702/129 Harrington Street
THE ROCKS NSW 2000

**REF: 35-75 HARRINGTON STREET, THE ROCKS NSW 2000 - Application Number
SSD-32766230 – City of Sydney**

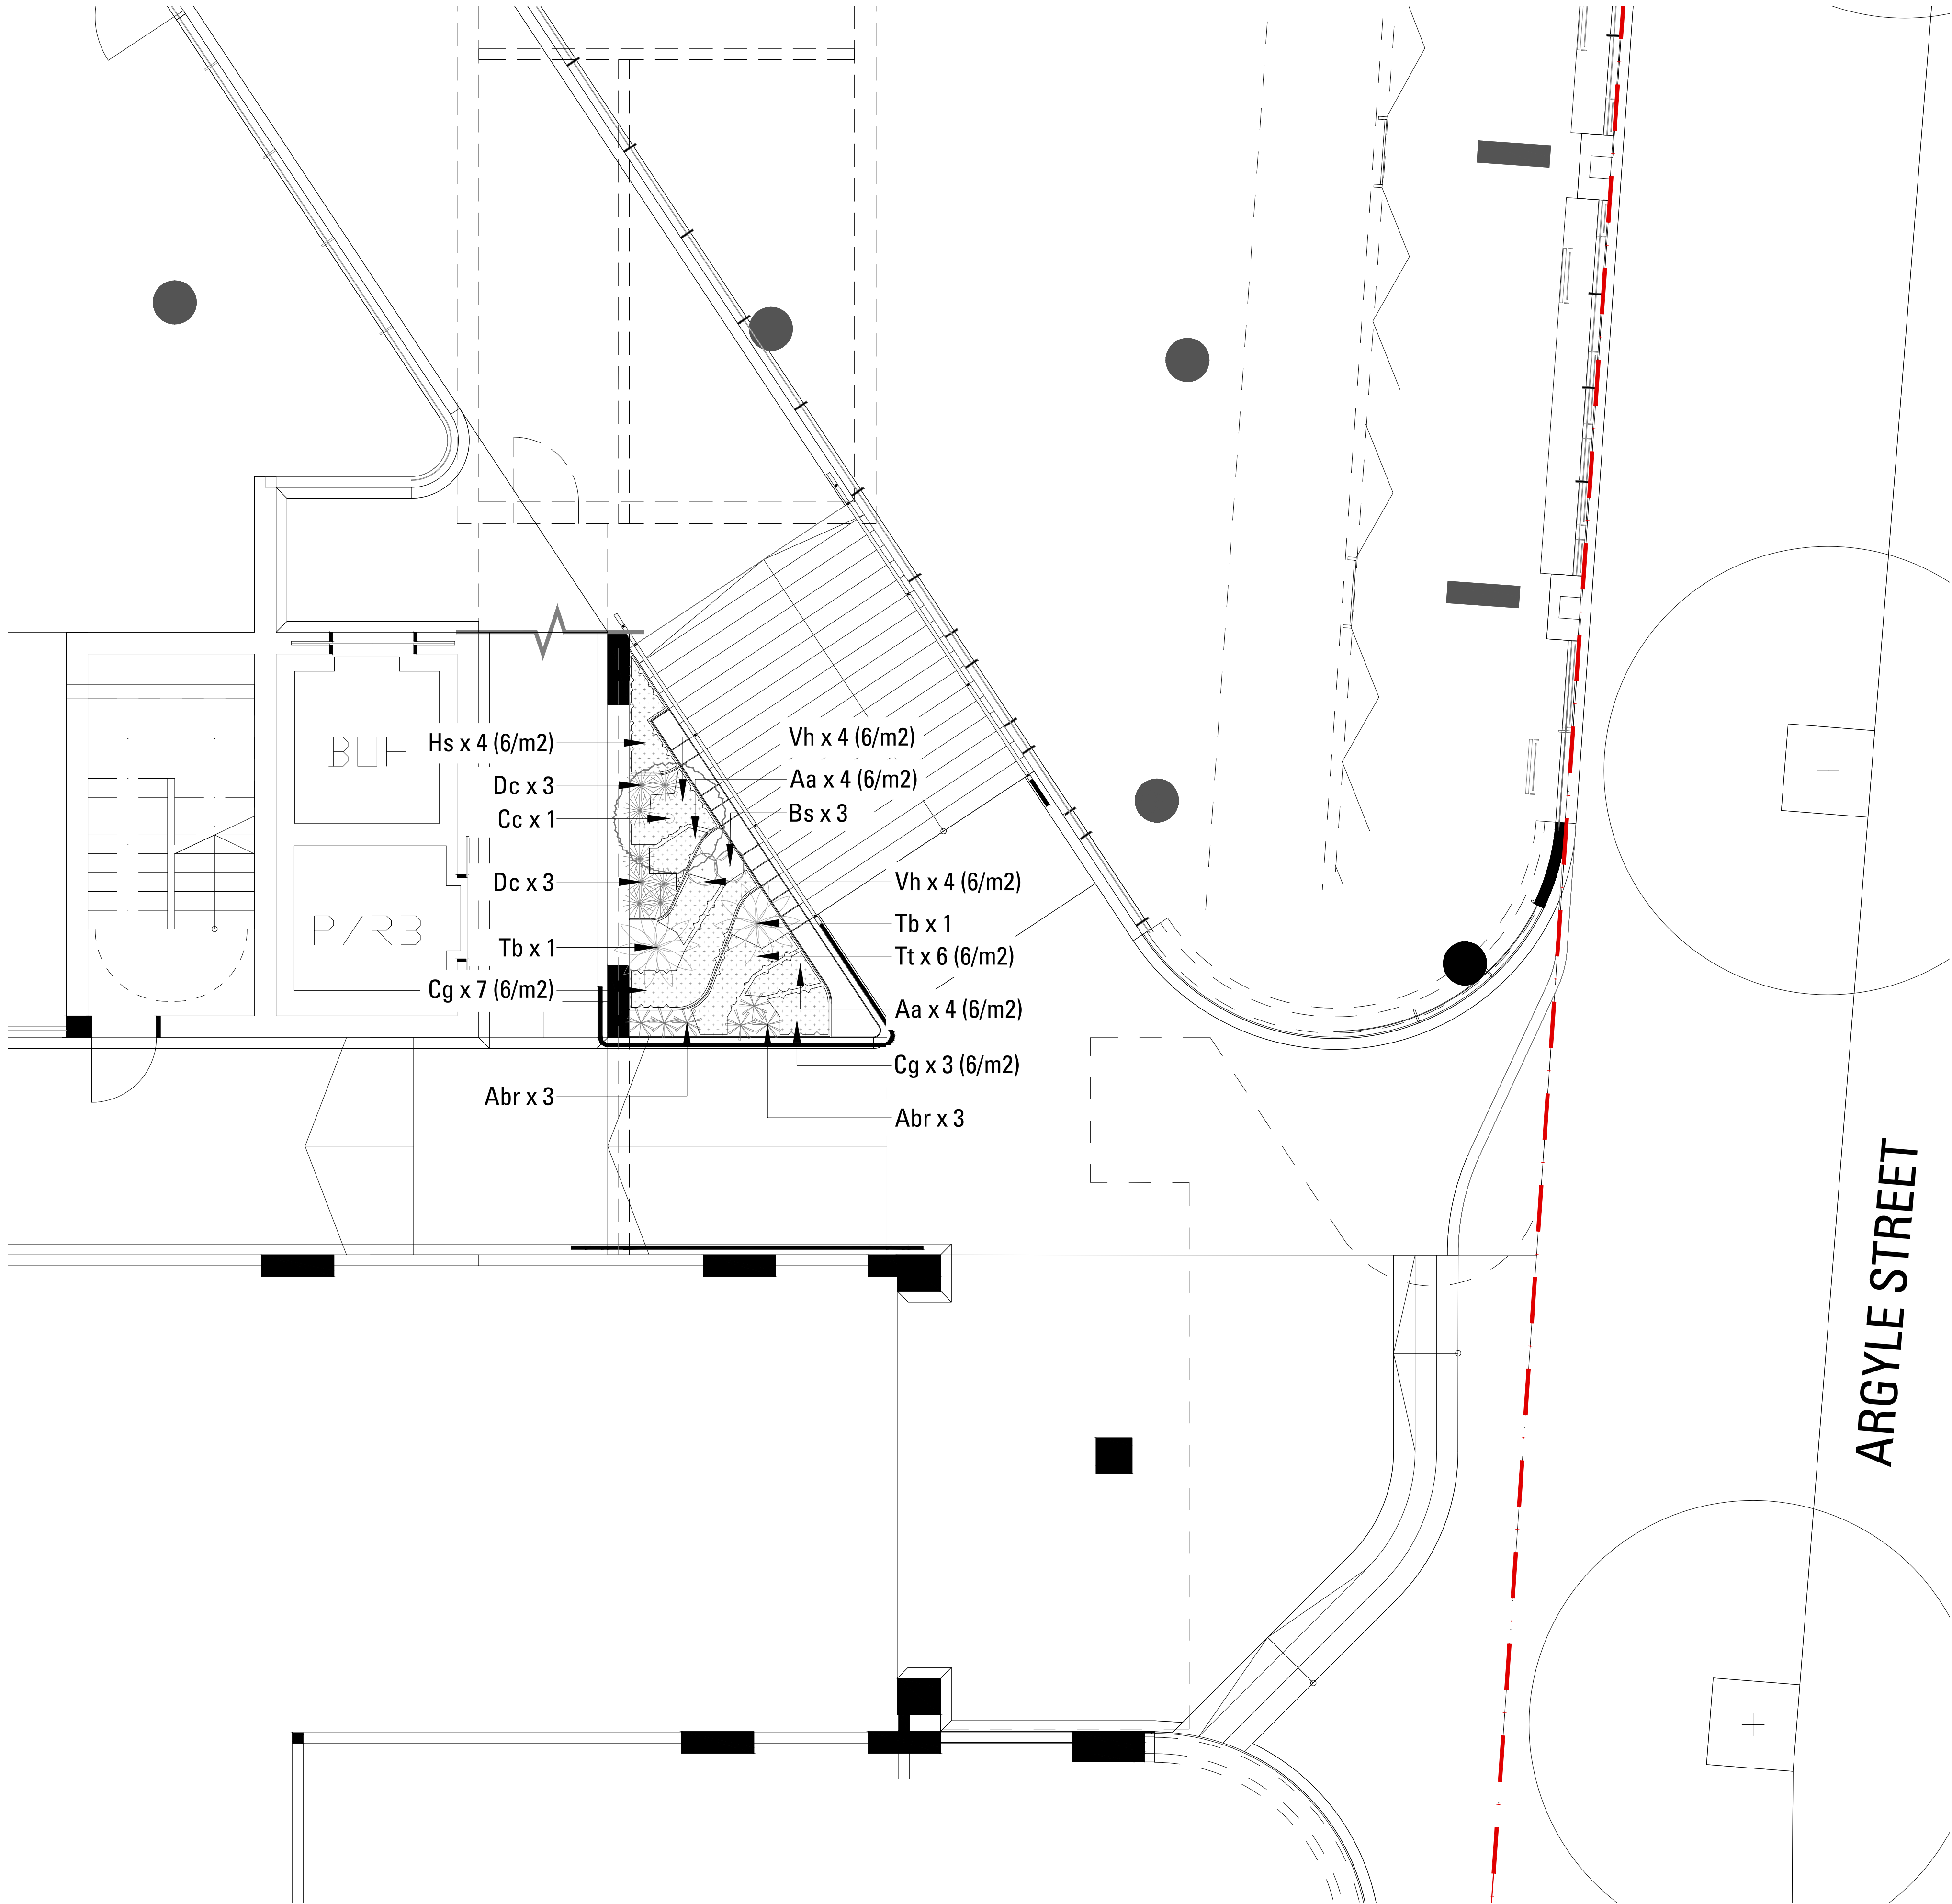
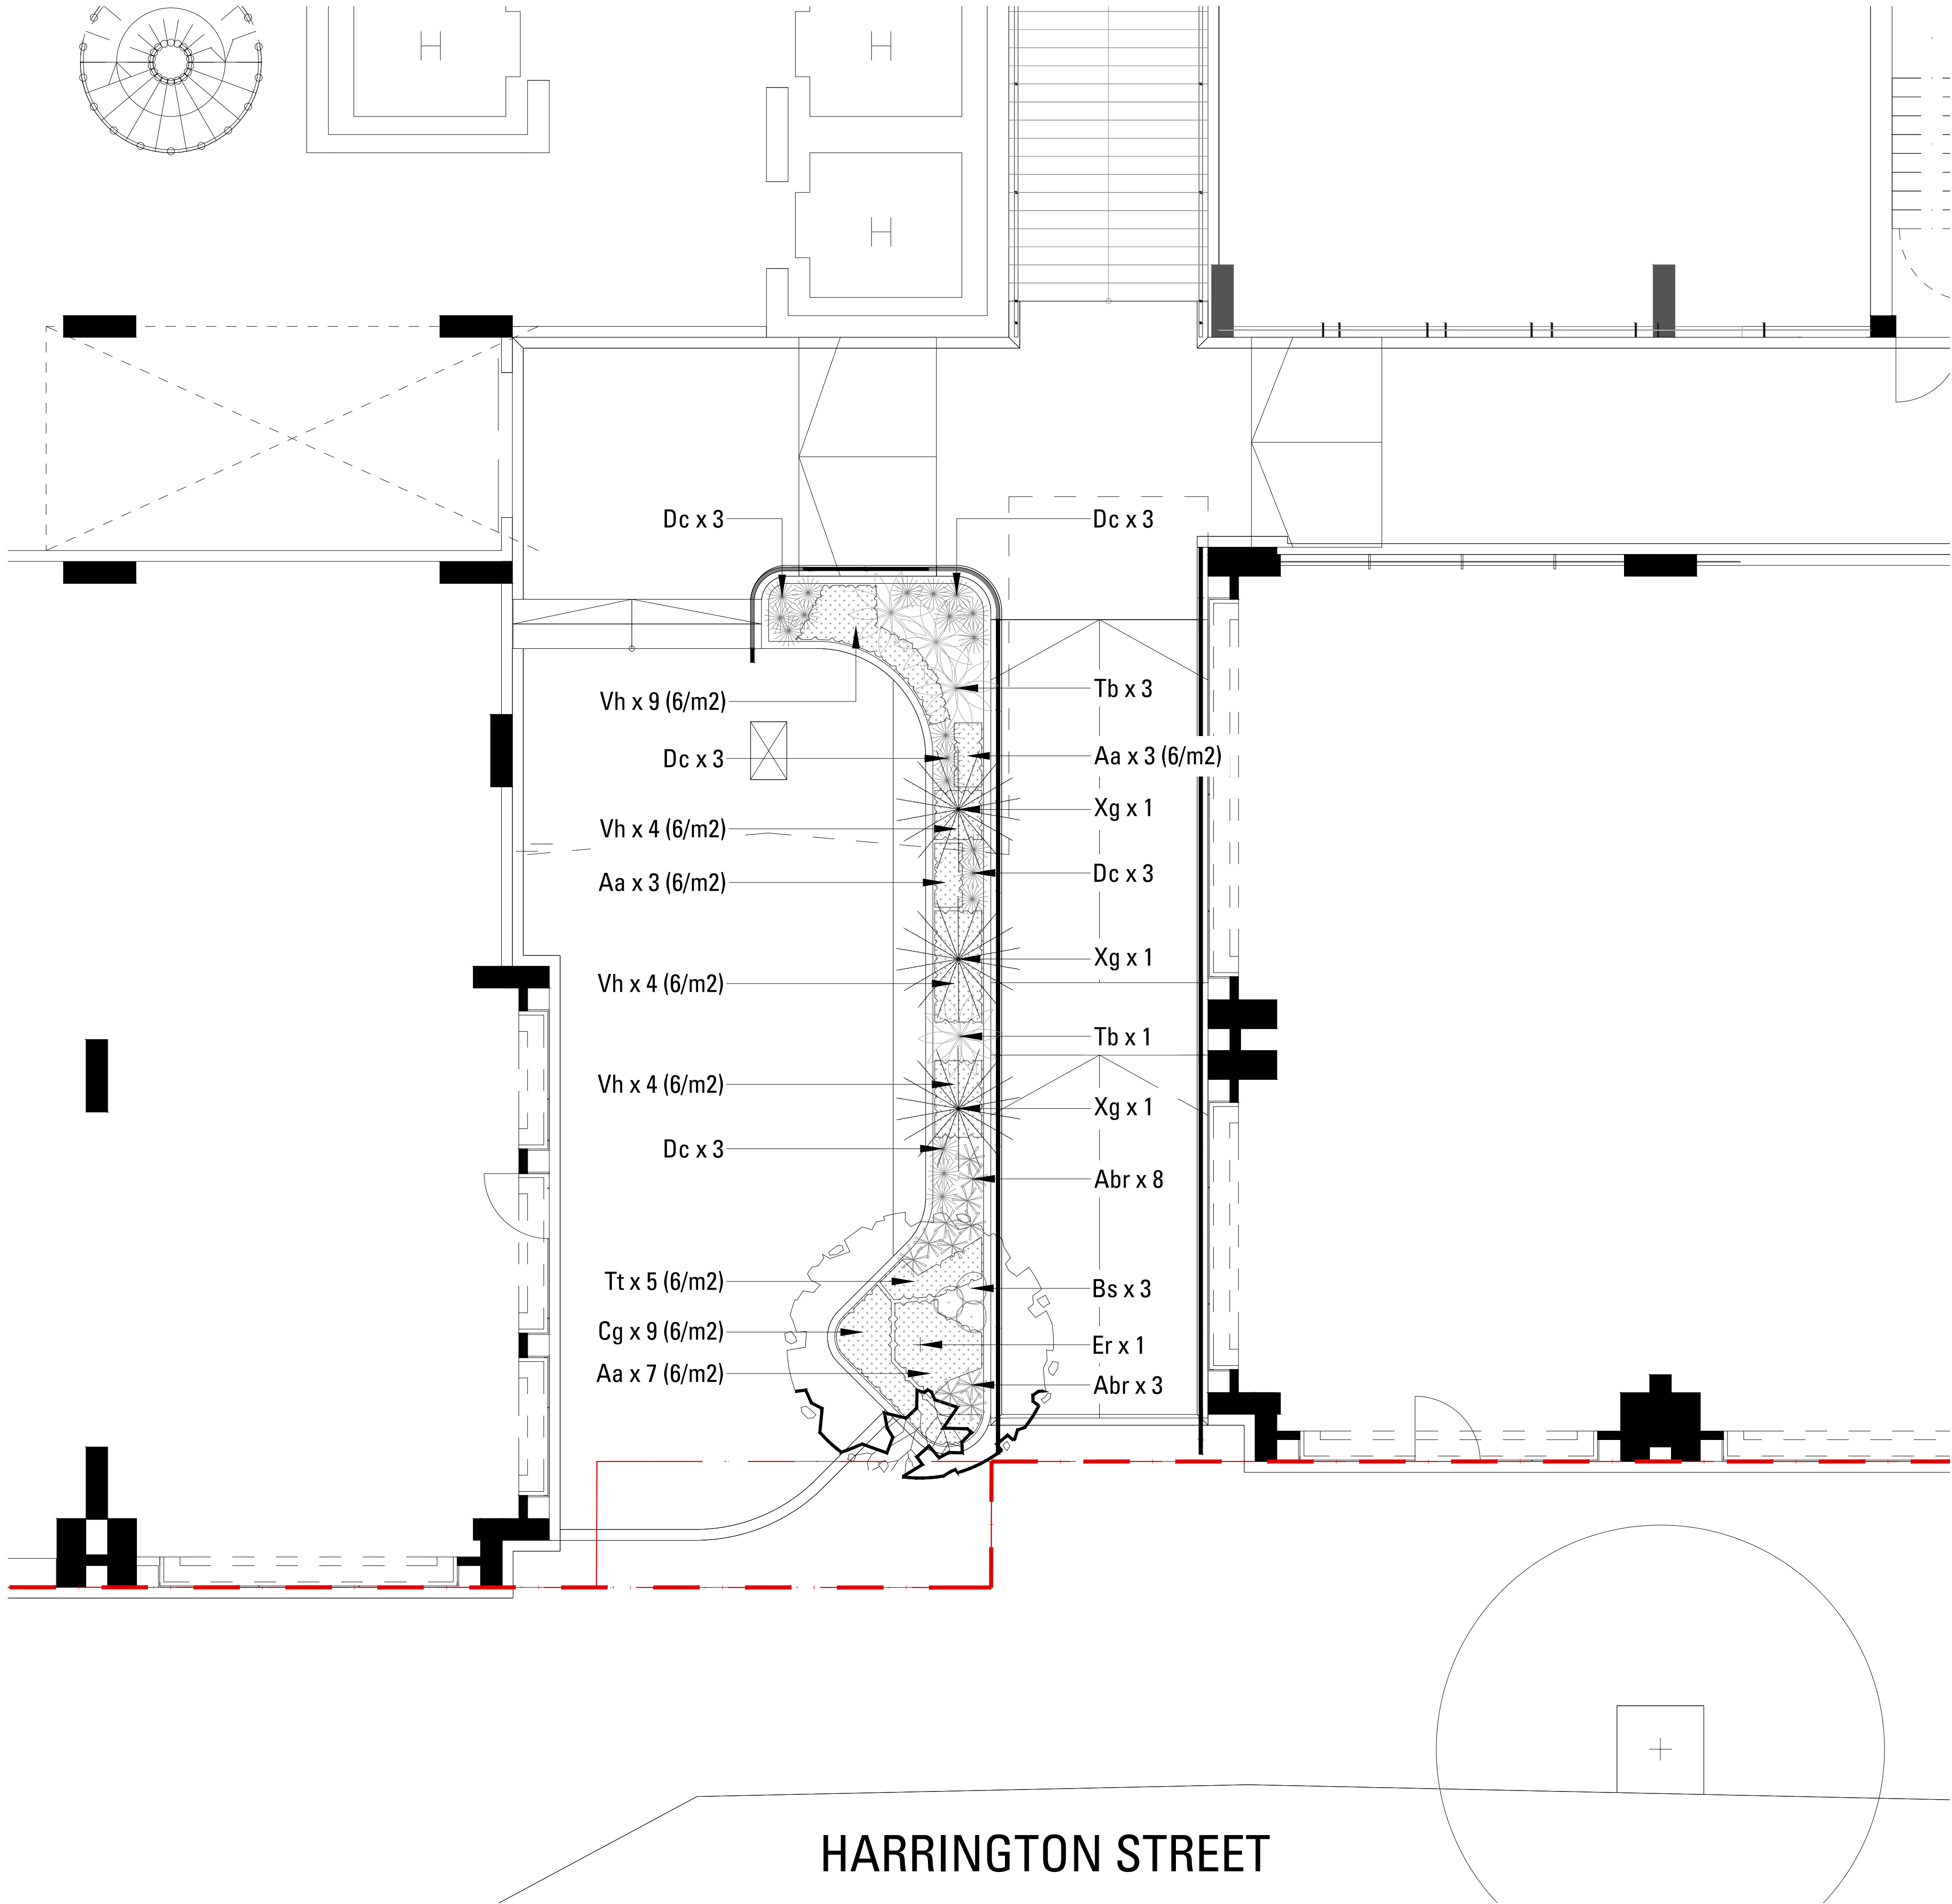
Please clearly demonstrate what sightlines I will lose, should this application proceed – see attached photograph.
